Cherwell District Council: Begbroke Science Park, Begbroke Hill, Begbroke, Kidlington, OX5 1PF

On behalf of our client, Begbroke Oxford Limited (BOL), please find enclosed an application for a Non-Material Amendment (NMA) to full planning application (Ref. 21/03195/F) (dated 4 February 2022) for:

“Formation of surface car park and service building (including substation, sprinkler tanks and EV charging infrastructure)”.

DRAWING NAME:
PROPOSED FLOOR & ROOF PLAN - SERVICES BUILDING

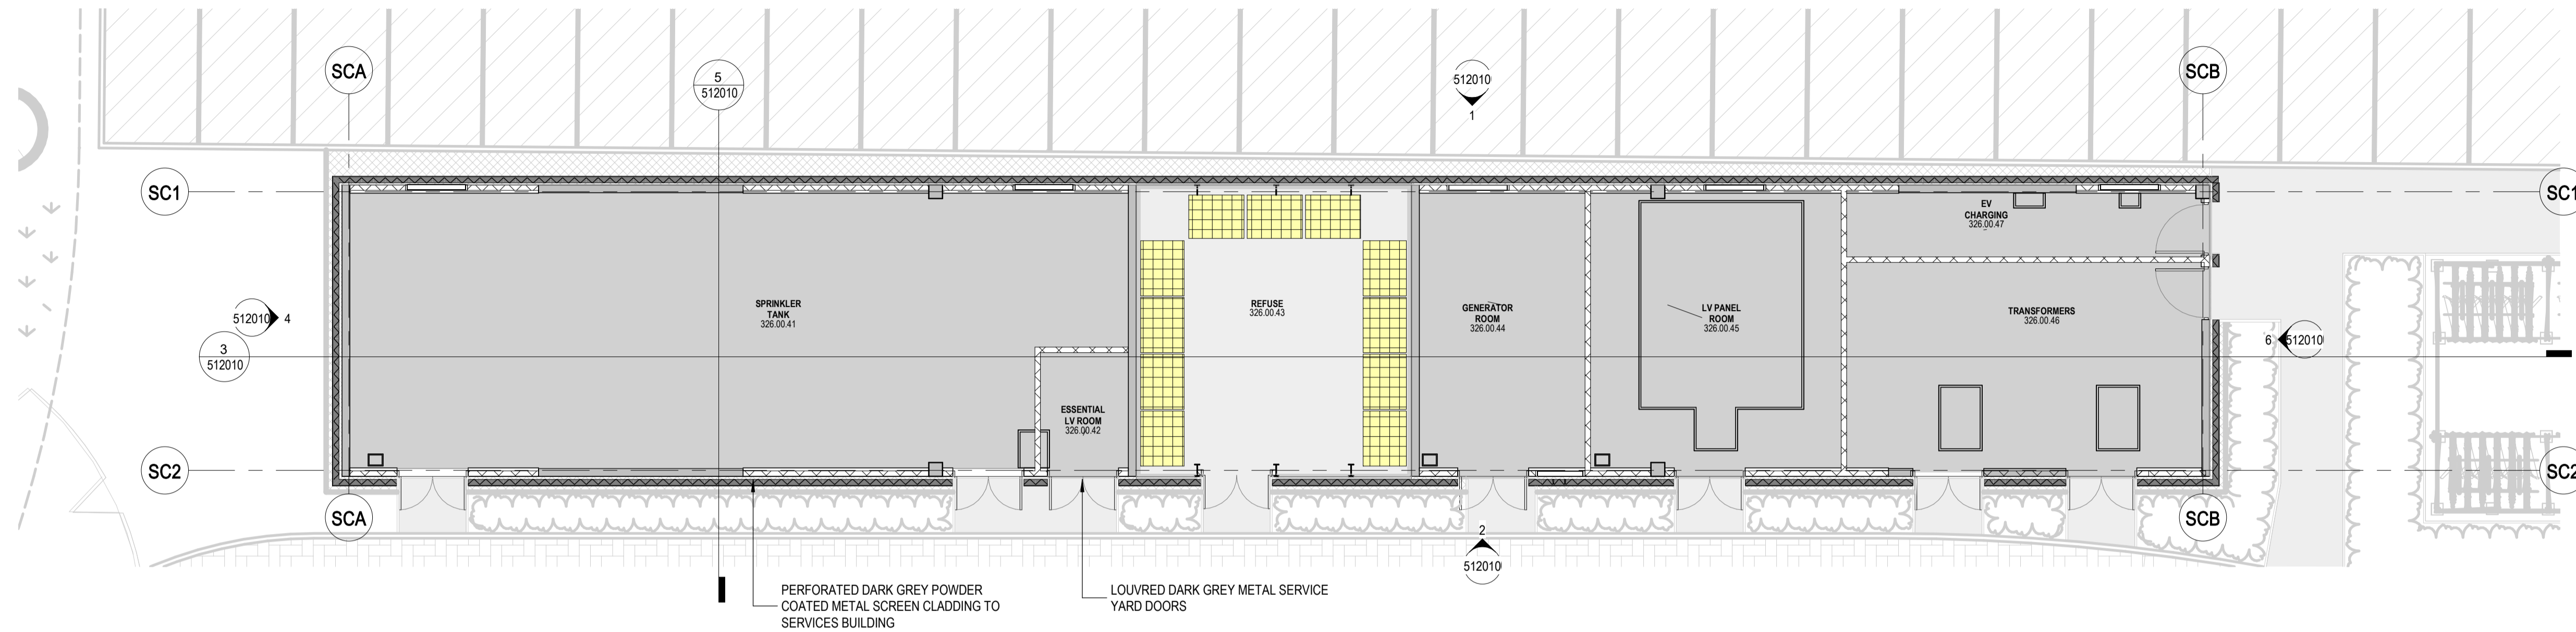
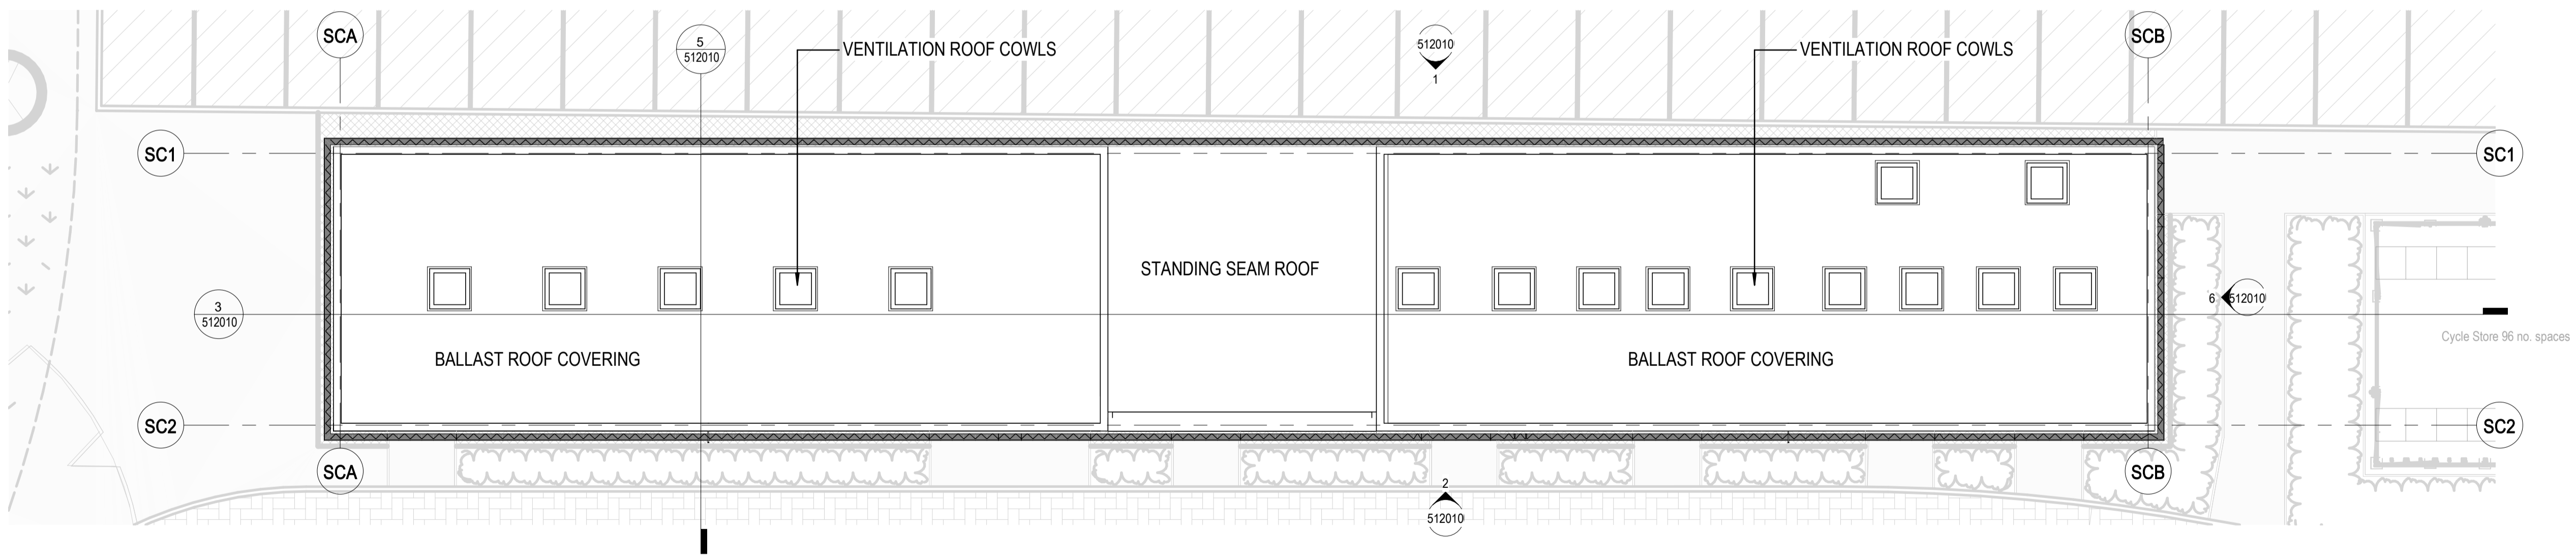
- 1 Height reduction from 4500mm to 4300mm;
- 2 Ventilation cowls added to the roof;

- 3 Roof finishes change (albeit this area is not visible to the public);
- 4 Doors location and sizes change; and
- 5 Additional door added on East elevation.
